RE: Jurisdiction Comments provided by Grace Manahan:
Permit Application: 2312-185
Site Address: 8477 SE 68TH STREET, MERCER ISLAND, WA 98040
Crown Site Number: 880416 / Crown Site Name: SEATTLE QWEST - SEA155
Customer Site Number: 5000381667 / Application Number: 640386

On behalf of Seattle SMSA Limited Partnership d/b/a Verizon Wireless (“Verizon Wireless” or “Applicant”), Crown Castle USA Inc. (“Crown Castle”) is submitting this letter to address the comments received January 29, 2024 regarding permit application 2312-185.

SHEET NUMBER: **C-2** REVISION: **5**

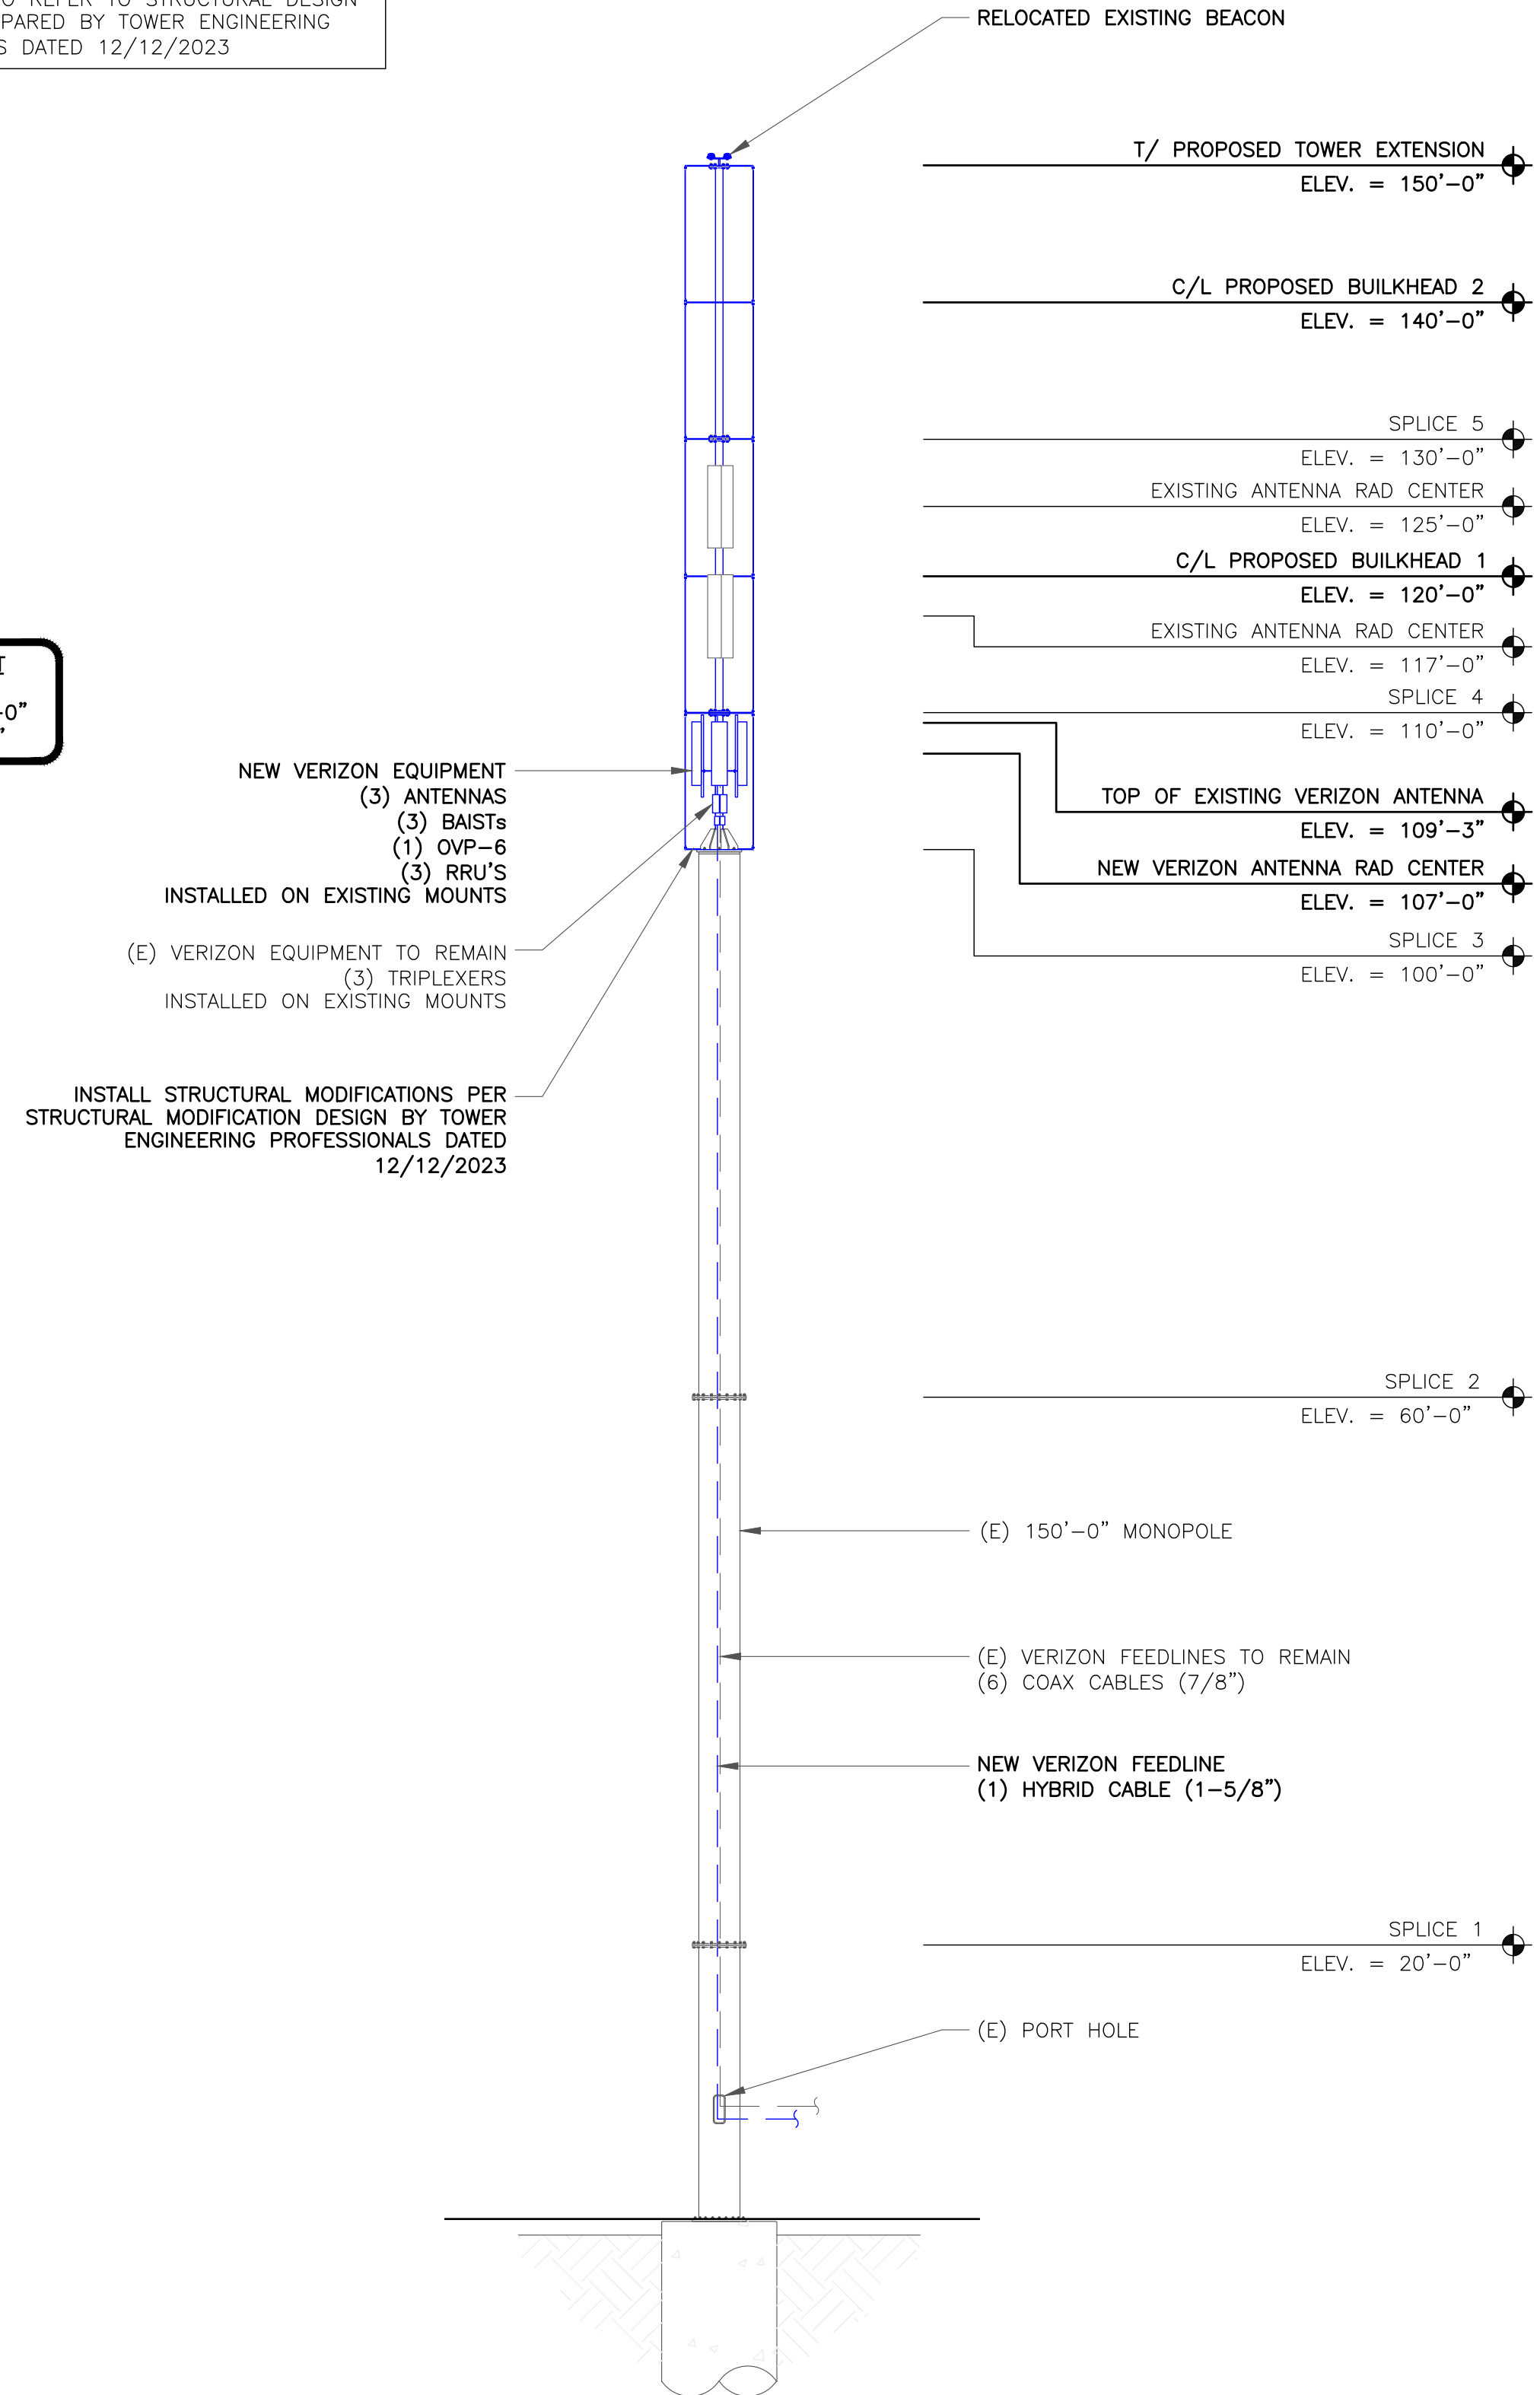
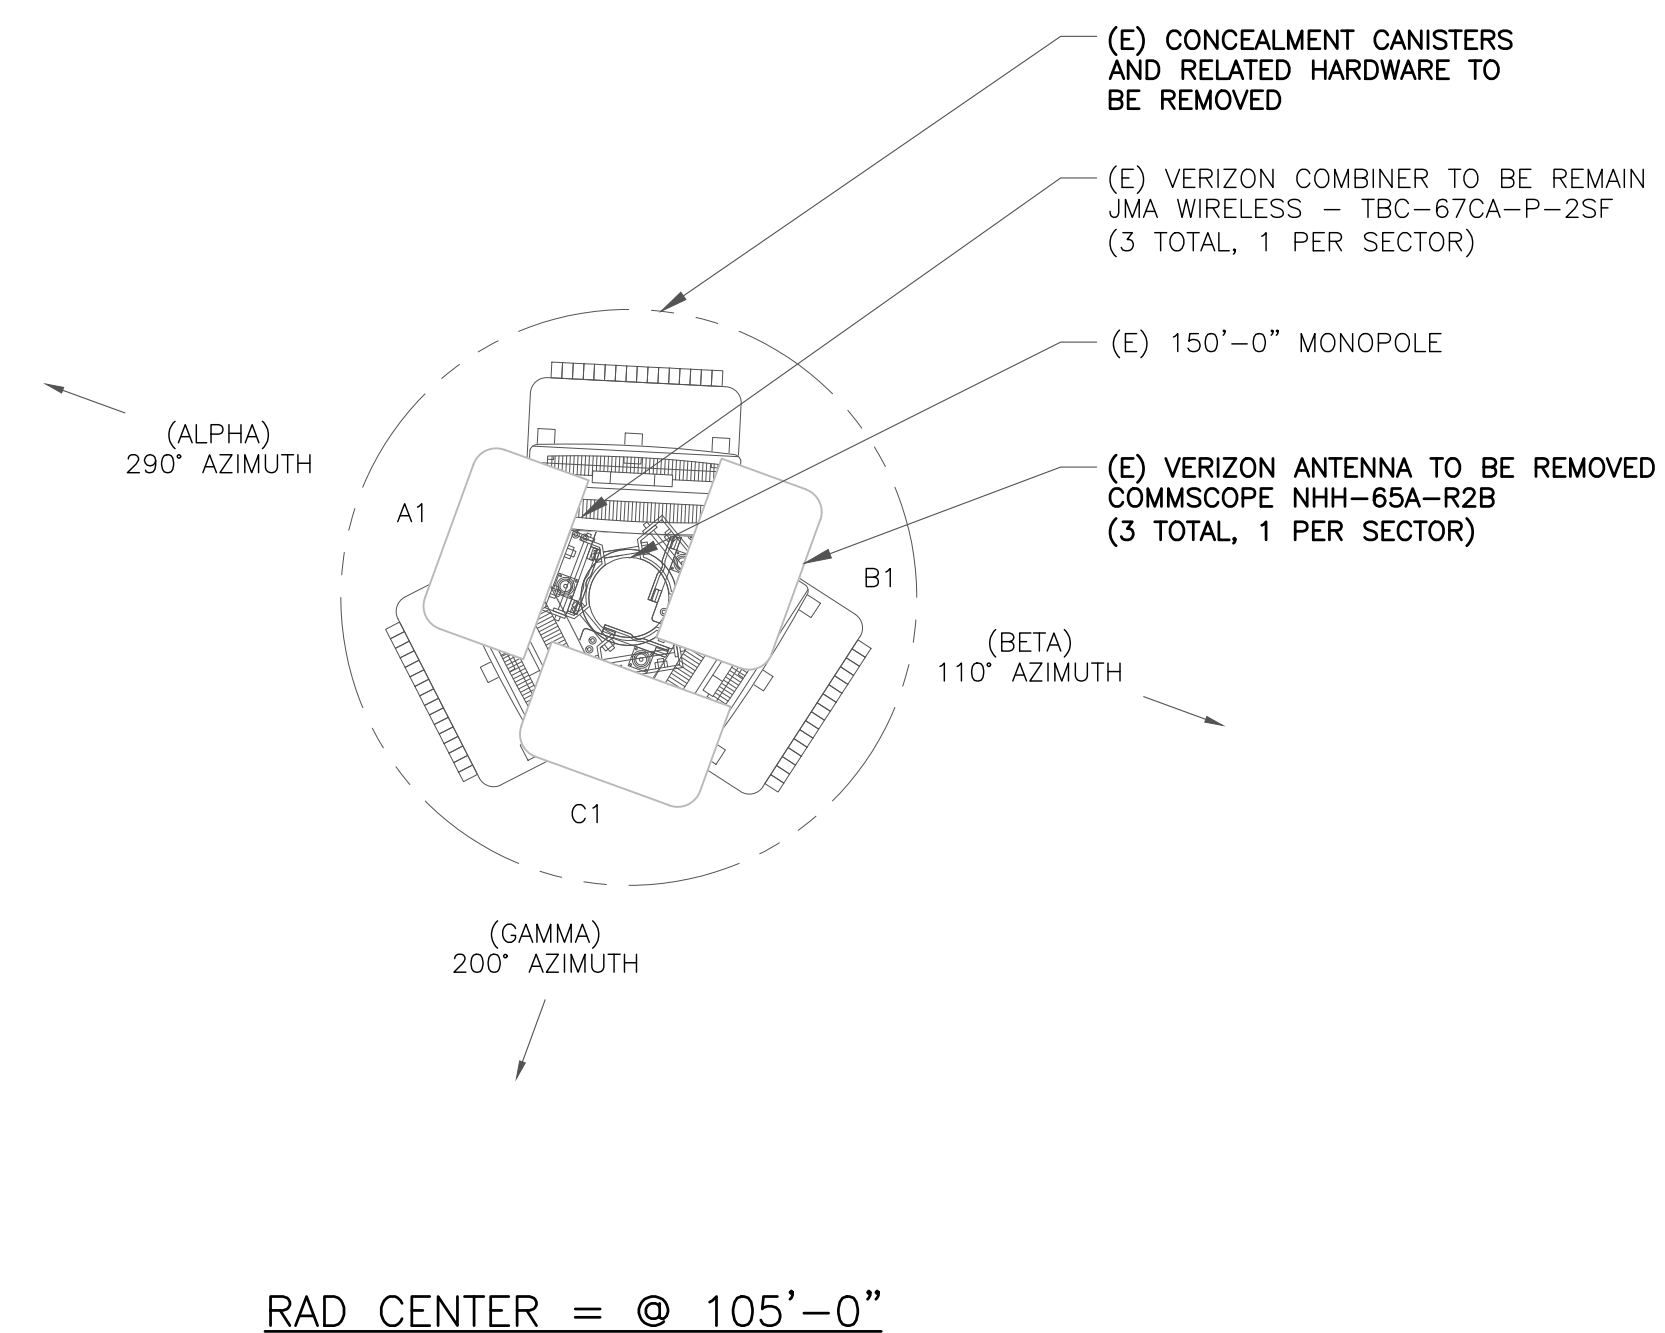
1. The last permit for this property (2304-091) showed the top of shroud at elev. = 130'. Clarify scope of work and clarify existing vs proposed conditions.

Response: Tower extension was approved under Dish Wireless permit number 2310-081.
